**FOR REVIEW**

VALENS CAPITAL, LLC  
 SITE DEVELOPMENT PLAN  
 3980 Walker Road, Colorado Springs, CO 80908  
 719-425-6111  
 donna.d.shell@gmail.com

SHEET  
**C1**

SITE PLAN KEYMAP

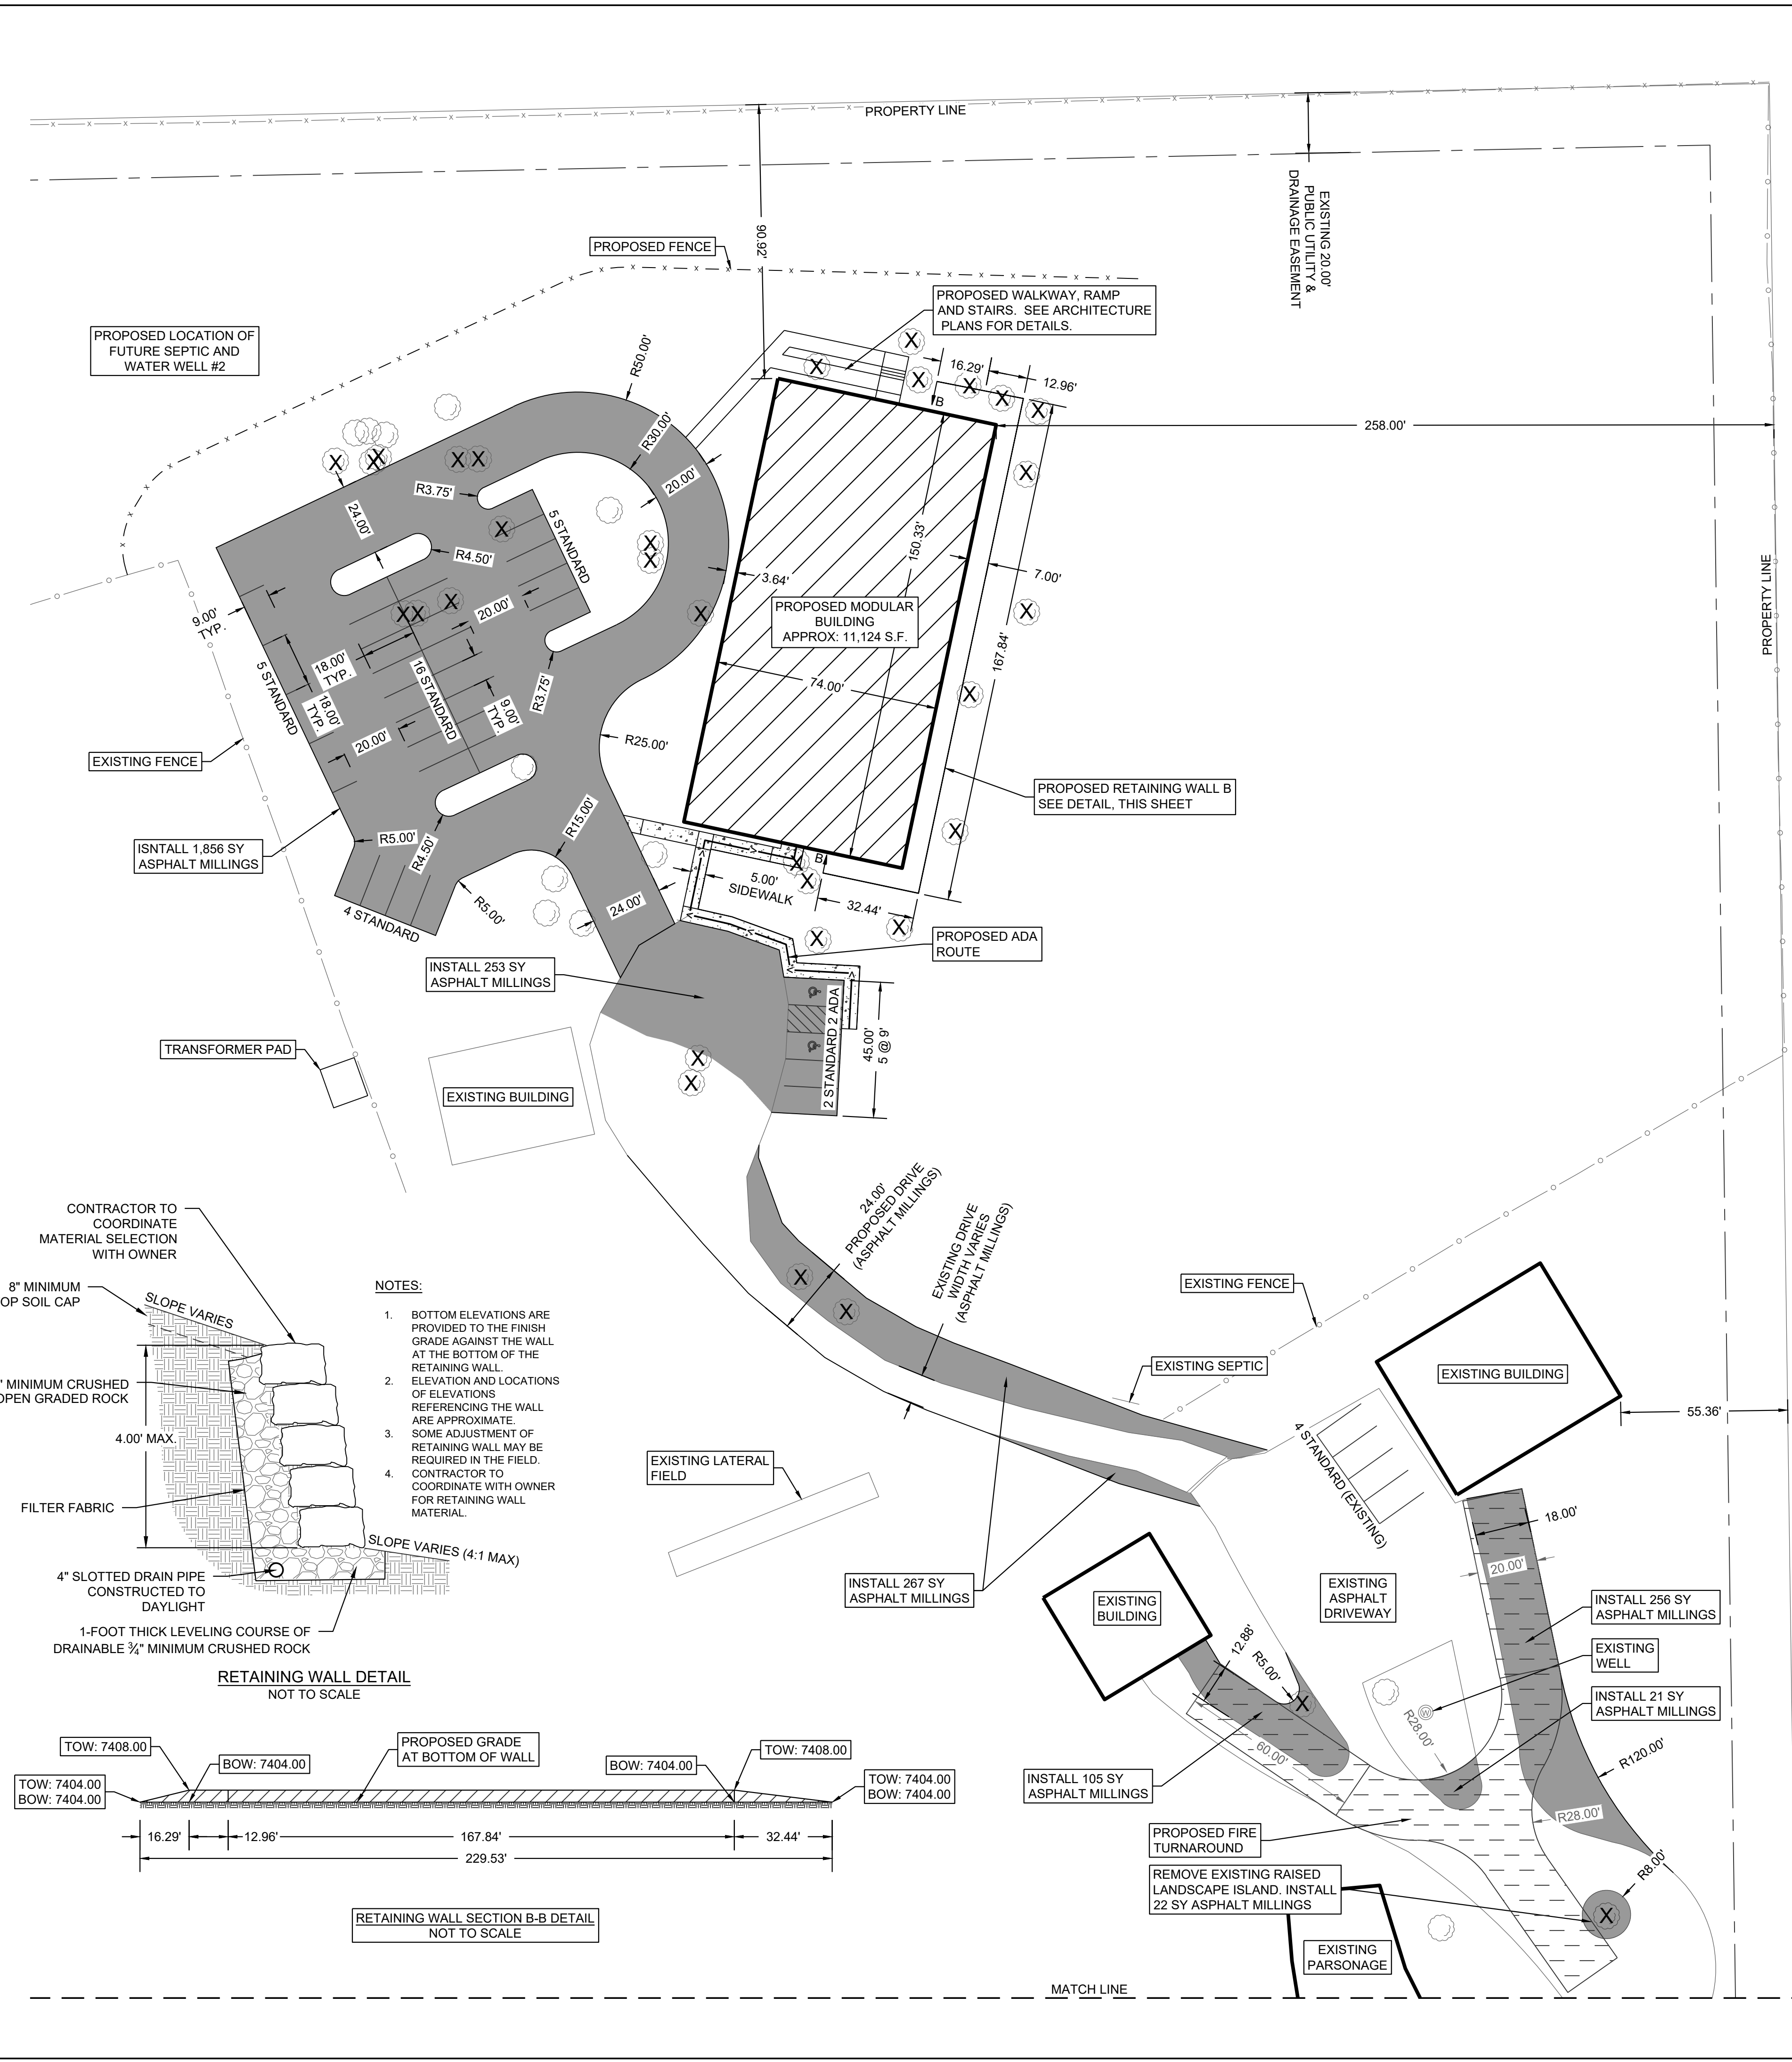
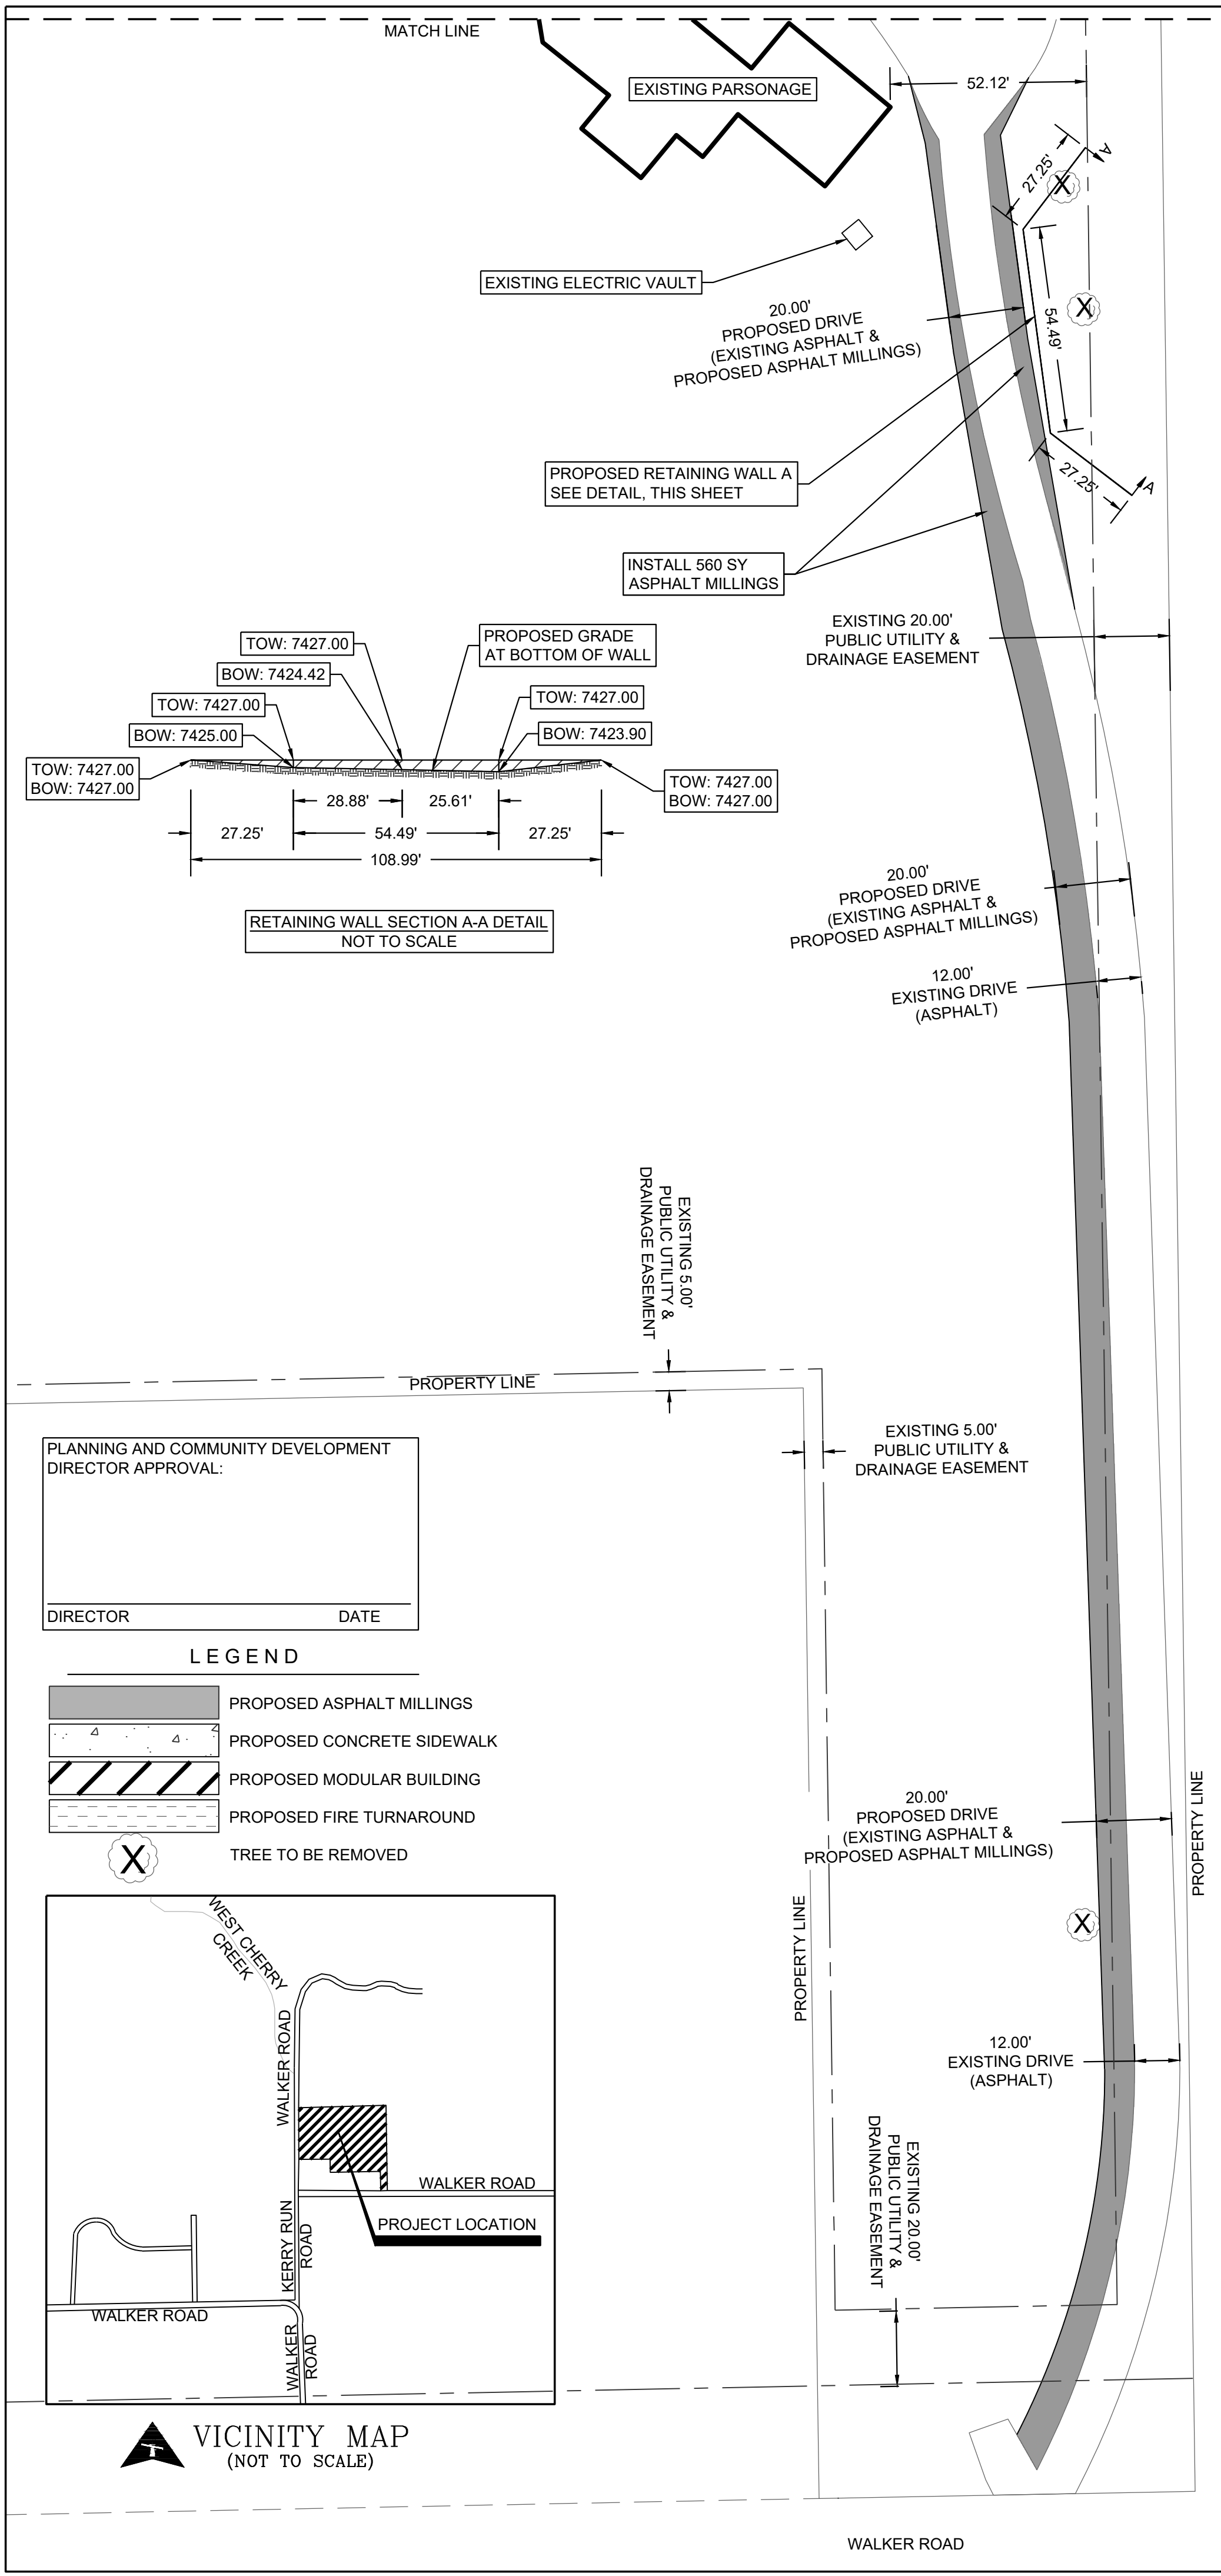
Please show the proposed grading necessary for the proposed improvements shown on this plan.

The proposed improvements by themselves (highlighted in orange) without any grading will disturb very close to 1ac of land (or above 1ac, depending on what the drawing scale ends up being. Per Daniel's comment below, the scale appears to be off). Once you show the grading on here, if it exceeds 1ac of disturbance, an ESQCP and its related documents (listed below) will be required.

Parking Requirements for Religious Institution are 1 space per 4 seats. Please include total number of seats.

You appear to be using parking calcs for Professional Office space?

Please show distances of all existing and proposed structures from property line.

Please identify the width of the driveway and the material to be used. If this is an existing driveway and surface material is not changing then please indicate that.

please verify the drawing scale as it does not appear correct
